State of Washington
DEPARTMENT OF FISH AND WILDLIFE

September 26, 2023

SUBJECT: WDFW COMMENTS ON CU-23-00003 Fowler Creek Guest Ranch

EXHIBIT 16 - SITE PLAN - FOWLER CREEK GUEST RANCH

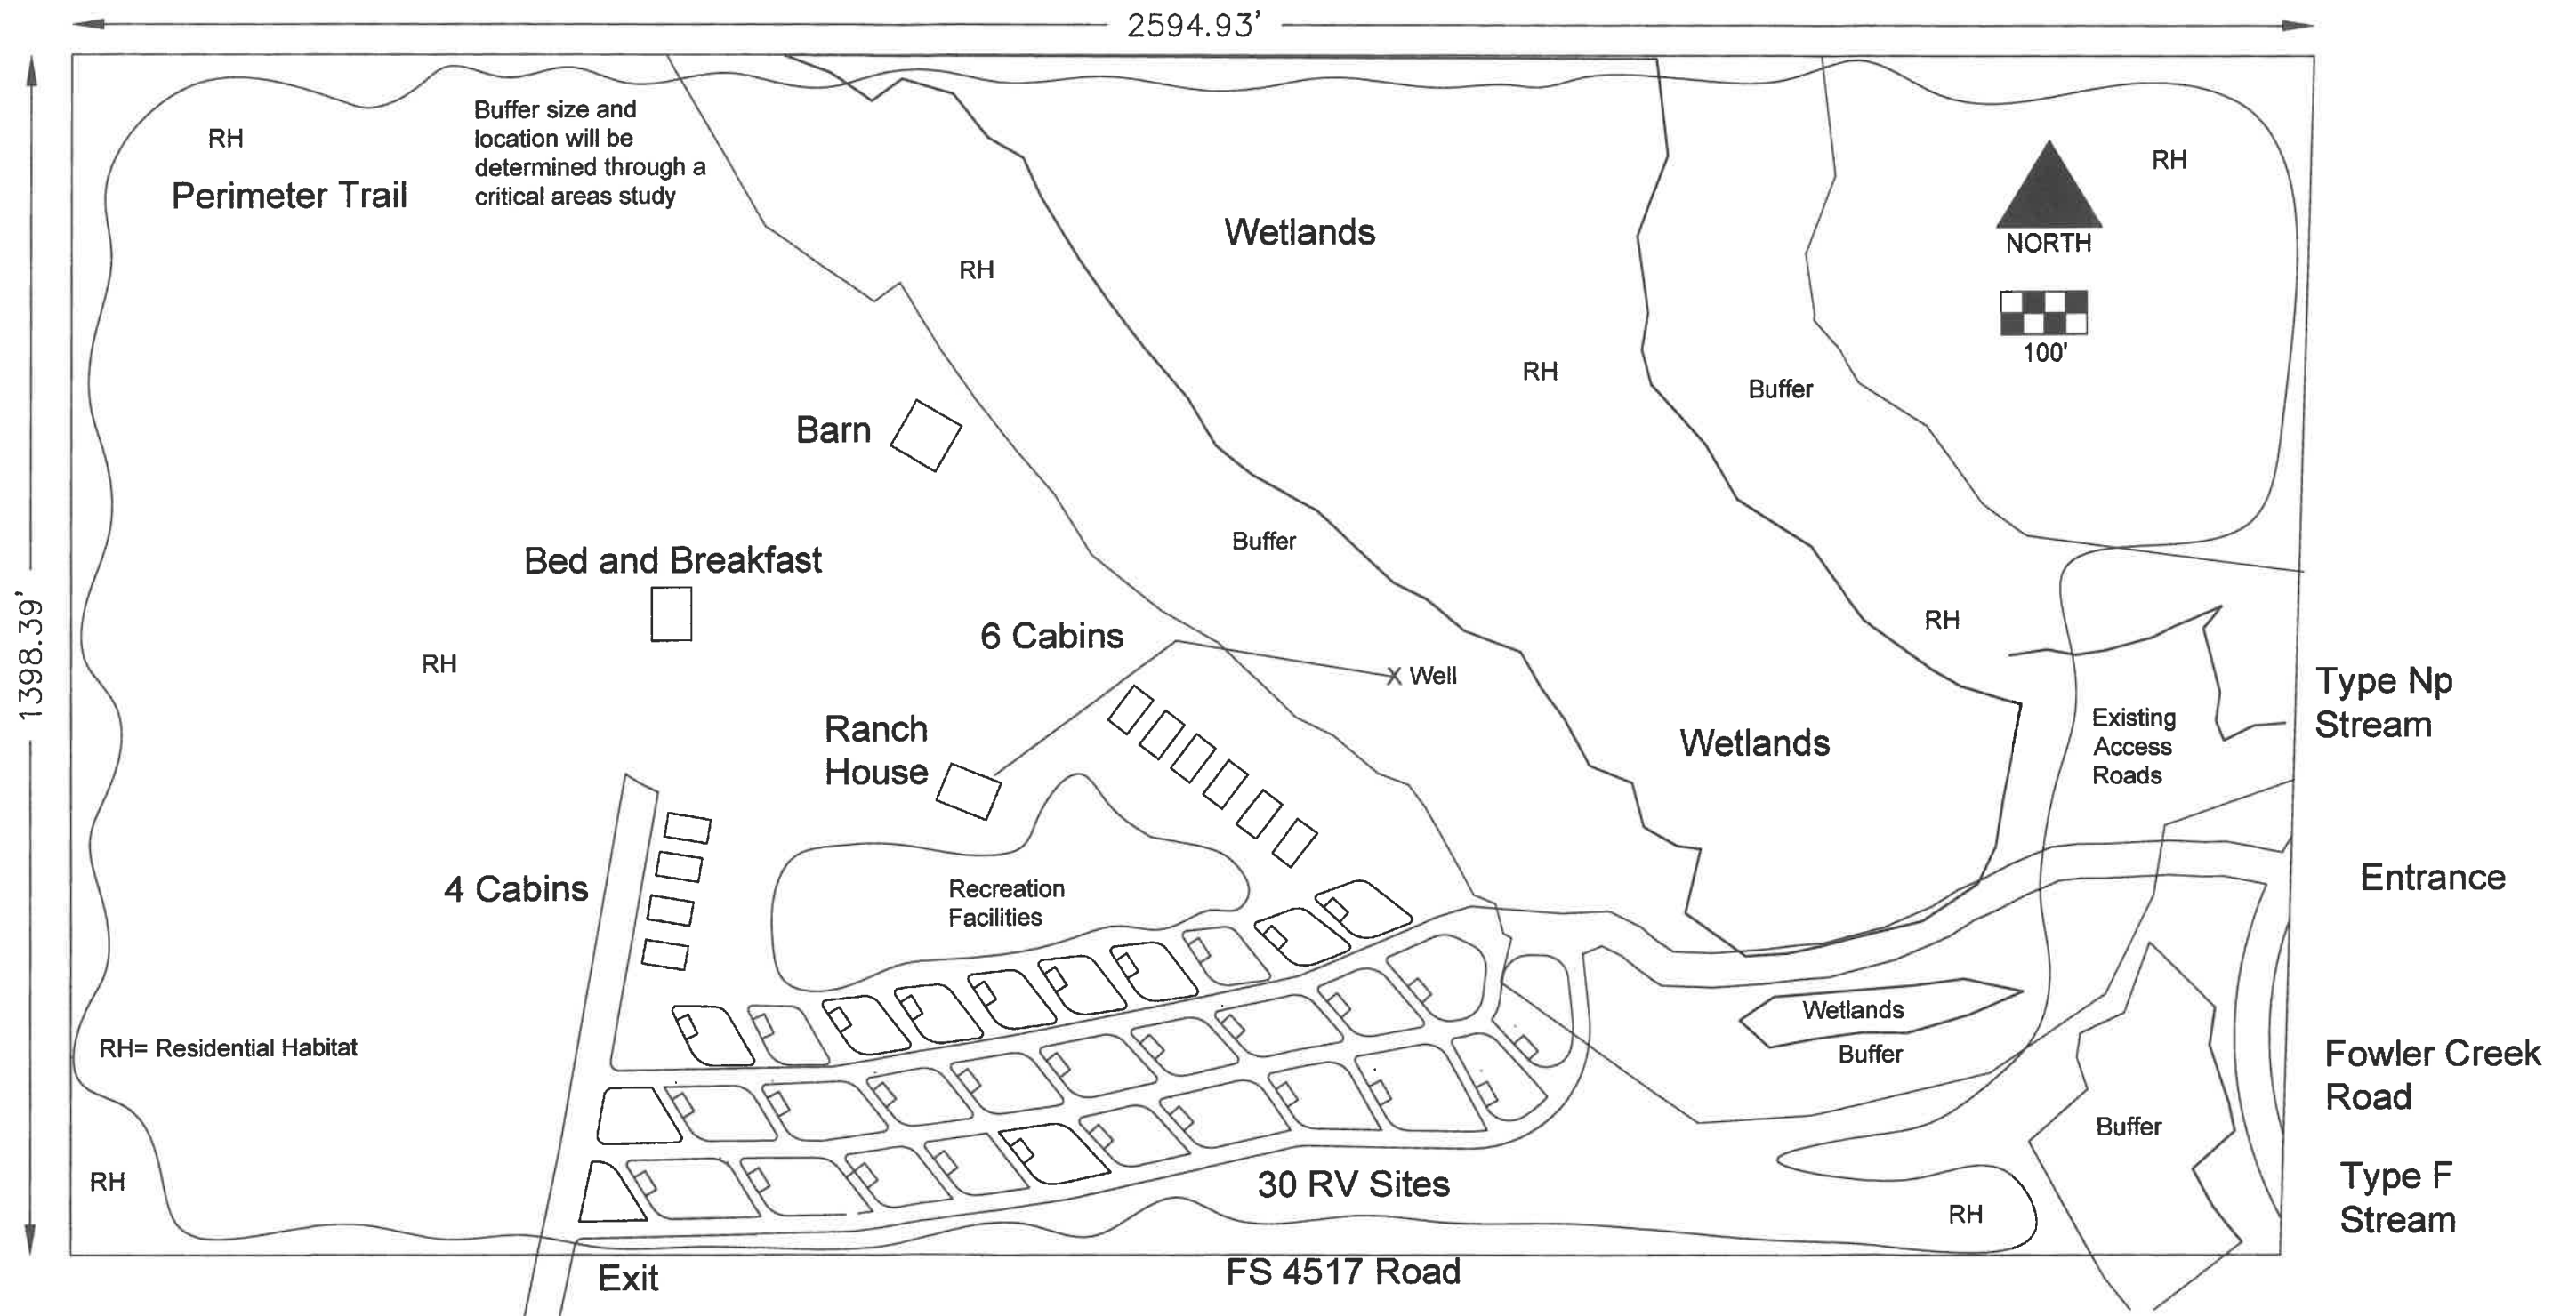
While we appreciate that the application has identified some of the larger wetlands and streams on the property and alluded that critical areas report would be conducted, WDFW requests that a critical areas report be conducted prior to approval of a site plan to ensure that all streams and wetlands are identified, and their appropriate buffers be incorporated into the final site plan. WDFW would also request the opportunity to review and provide comments to the county on the report.

The application alludes to building of "residential habitats", trails, viewing platforms etc.. within either the stream or wetland area buffers. While WDFW is not directly opposed to this concept, it is vital that these structures do not result in a net loss of functional habitat within the wetland or riparian areas. WDFW requests that if these structures are approved, a condition be imposed that a detailed site plan be reviewed prior to any building and that either the structures themselves result in not net loss of function or that appropriate mitigation be proposed for the loss of function from these structures. Examples of loss of function include removal of overstory trees, removal of significant amounts of shrubs or understory vegetation, impervious surfaces or structures that prevent natural vegetation or functions from occurring, including that trees near these structures could now be deemed to be hazard trees. WDFW requests to be involved in the review of the site plans of trails and structures in the critical areas and evaluation of loss of function as an agency that has expertise in the FWHCA.
